Application no: H02/0964/01

Description: Extension and new vehicular
access

Location: 13 Kemp Street
Crowland

Amendment: Amend gable roof to a hipped ended roof
Dwg. no. 2144-09A

B N A 57a St Margarets Road Peterborough PE4 9EA Tel 01733 703320			
Project : EXTENSION TO 13 KEMP STREET CROWLAND			
Title : PROPOSED ELEVATIONS			
Date 6/08/01	Scale 1:50	Drawn JRN	
Drawing No :			2144-09A

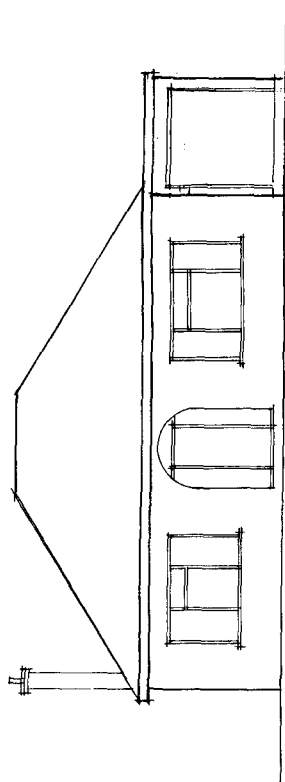
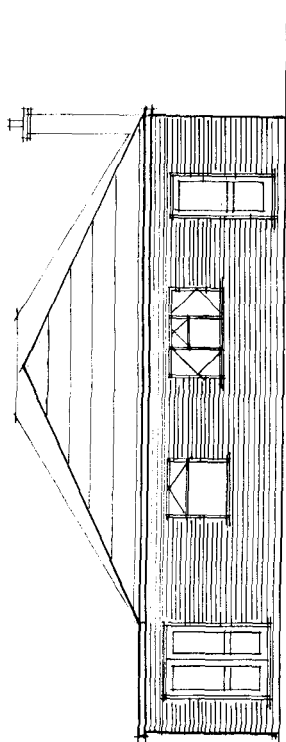
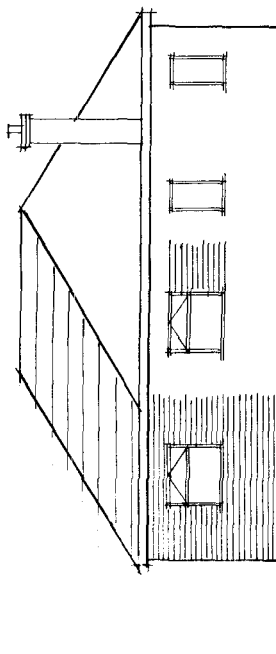
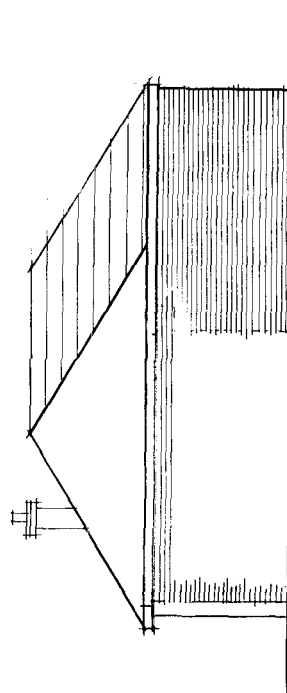
AMEND GABLE ROOF
TO A HIPPED ENDED
ROOF

Please find enclosed 6 copies of our revised plan 2144-09a showing a hipped ended roof to the proposed extension rather than a gable. can this be considered an over lay to the original application drawings?
